15 August 2017

Canoe Bay Retirement Community
 51 Cortleigh Drive
 Ottawa, ON K2J 3Z8

**Re: 3071 Riverside Drive – Canoe Bay Development
 Transportation Impact Study – Addendum #1**

1 SITE PLAN
SP-1
SCALE = 1 : 500

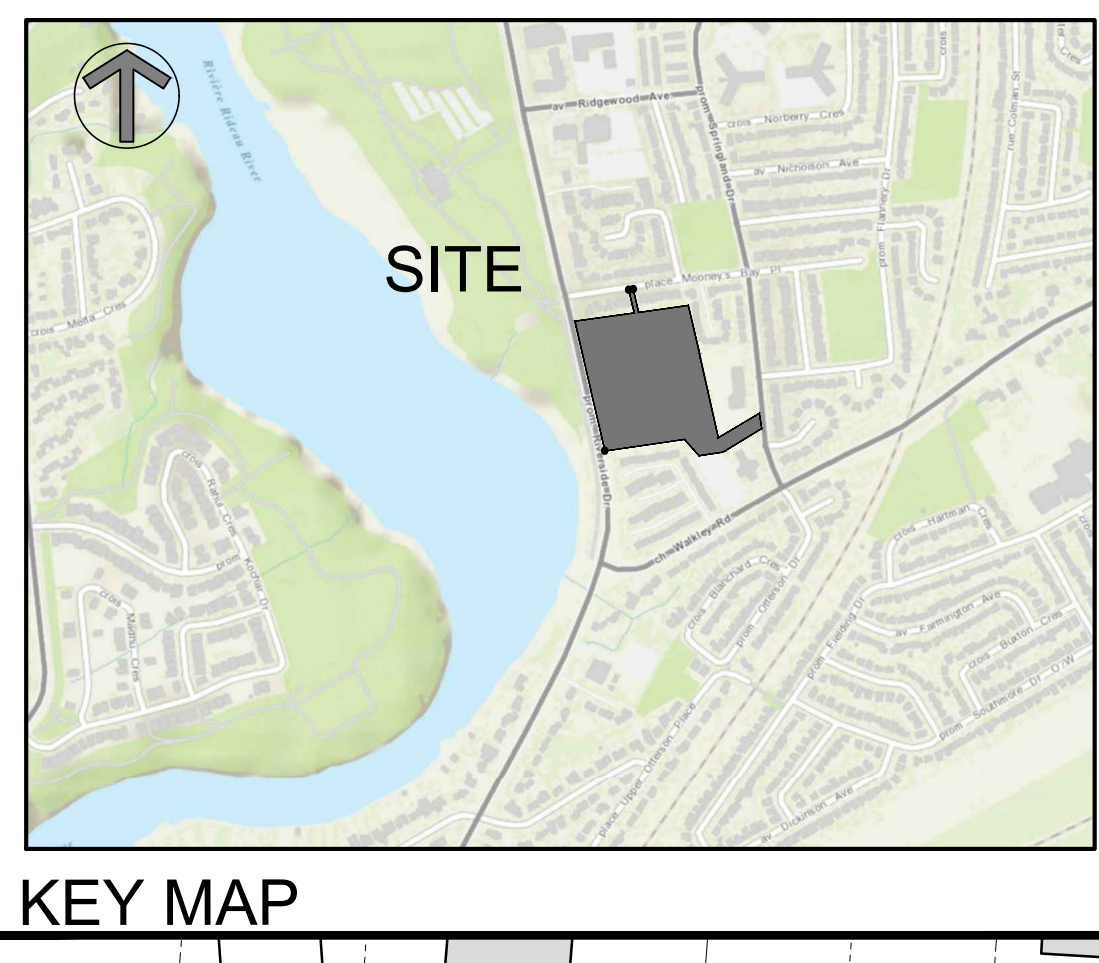
This Addendum to the original Community Transportation Study/Transportation Impact Study (CTS/TIS) has been prepared to identify the transportation-related changes to the Site Plan and address any impacts these changes will have on the overall results of the original study. The revised Site Plan is attached and includes the following transportation-related changes:

- Removal of the right-in/right-out driveway connection to Riverside Drive which provides direct access to underground parking garage;
- Slight decrease in residential units from 627 to 617 units;
- Slight increase in parking from 434 to 460 spaces;
- Relocation of the day-care facility from Springland Drive to ground floor of the northwest building; and
- Increase parking lot size on Springland Drive from 11 spaces to 25 spaces (staff parking).

With regard to the change in residential units, this will have a negligible impact on the trip generation analysis from the original report. The revised vehicle parking supply for the entire site meets the City’s By-Law requirements. It is noteworthy, however, that for Building Type ‘B’ (apartments) and ‘C’ (mixed-use), the parking is slightly undersupplied and for Building Type ‘D’ and ‘E’ (retirement home) the proposed provided parking is over the minimum requirement by approximately 90 spaces. This is outlined on the revised Site Plan.

With regard to the relocation of the daycare and the increase in vehicle parking supply along Springland Drive, the resulting vehicle trip distribution will be similar to the original TIS/CTS. As shown, approximately 20 two-way veh/h are projected to travel along Springland Drive to/from the proposed parking lot, which equates to less than 1 vehicle every three minutes along this local road.

The removal of the right-in/right-out vehicle access to the underground parking lot will increase vehicle traffic at the proposed signalized access and the right-in/right-out driveway connection to Riverside Drive at the north end of the site. In addition, it will likely reduce the number of U-turns at the proposed signalized access (Riverside/Site). The revised trip distribution is illustrated in Figure 1. Based on this redistribution of vehicle traffic, the resulting signalized access to the site is projected to operate acceptably, as shown in Table 1.
